**From:** Martina Gassner <[martina@escopacific.com.au](mailto:martina@escopacific.com.au)>  
**Sent:** Wednesday, 20 March 2019 2:43 PM  
**To:** Tim Stuckey <[Tim.Stuckey@planning.nsw.gov.au](mailto:Tim.Stuckey@planning.nsw.gov.au)>  
**Cc:** Rhiannon Olle <[Rhiannon@escopacific.com.au](mailto:Rhiannon@escopacific.com.au)>; Allison Hawke <[Allison@escopacific.com.au](mailto:Allison@escopacific.com.au)>  
**Subject:** RE: Wyalong Solar (SSD 9564) - More Information Required

**From:** Tim Stuckey <[Tim.Stuckey@planning.nsw.gov.au](mailto:Tim.Stuckey@planning.nsw.gov.au)>  
**Sent:** Monday, 18 March 2019 4:50 PM  
**To:** Martina Gassner <[martina@escopacific.com.au](mailto:martina@escopacific.com.au)>  
**Cc:** Iwan Davies <[iwan.davies@planning.nsw.gov.au](mailto:iwan.davies@planning.nsw.gov.au)>  
**Subject:** Wyalong Solar (SSD 9564) - More Information Required

**Re: Wyalong Solar Farm - Response to request for further information regarding noise assessment**

**Figure 2** | Project Layout

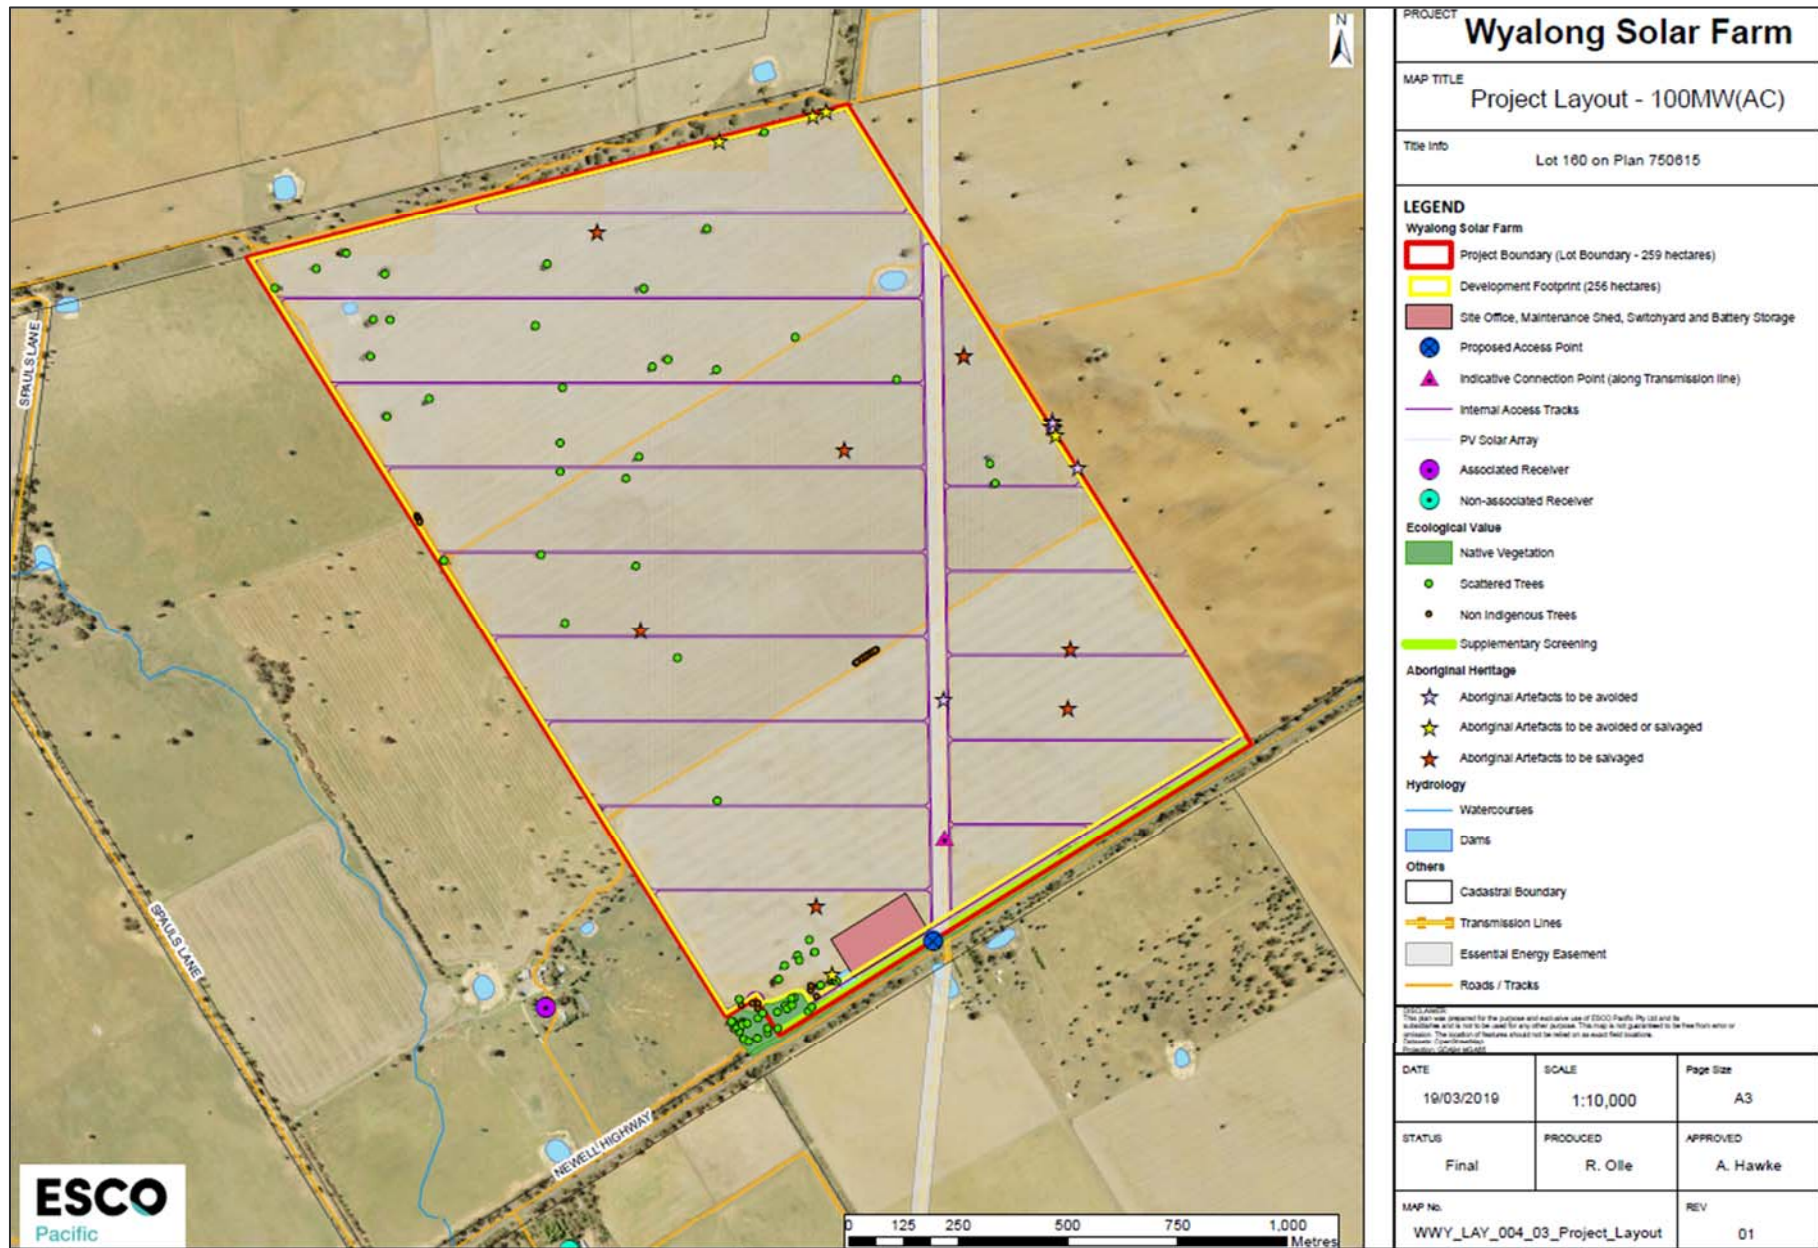
- visual impact – provide a revised landscaping and vegetation screening design, and confirm how this design will mitigate visual impacts to road users of the Newell Highway;

- mapping – revise Figure 3.1 (Project Layout) to comprise the following:
  - rename “Sensitive Receivers associated with the project” to *Associated Receiver*;

- rename “Sensitive Receivers” to *Non-associated Receiver*;
  - re-colour symbols for *Associated Receiver* and *Non-associated Receiver* to ensure they contrast against other symbols in the figure; and

- update figure to include vegetation screening design.

- visual impact – provide a revised landscaping and vegetation screening design, and confirm how this design will mitigate visual impacts to road users of the Newell Highway; **The Project Layout (Figure 3.1) has been revised to include the comments from DPE below. Supplementary screening has also been proposed along the southern boundary to mitigate the potential impacts (distraction/glare) for road users as raised by RMS and Bland Shire Council during the EIS Exhibition.**

- mapping – revise Figure 3.1 (Project Layout). **The Project Layout has been revised in line with DPE comments (please Wyalong Project Layout attached).**
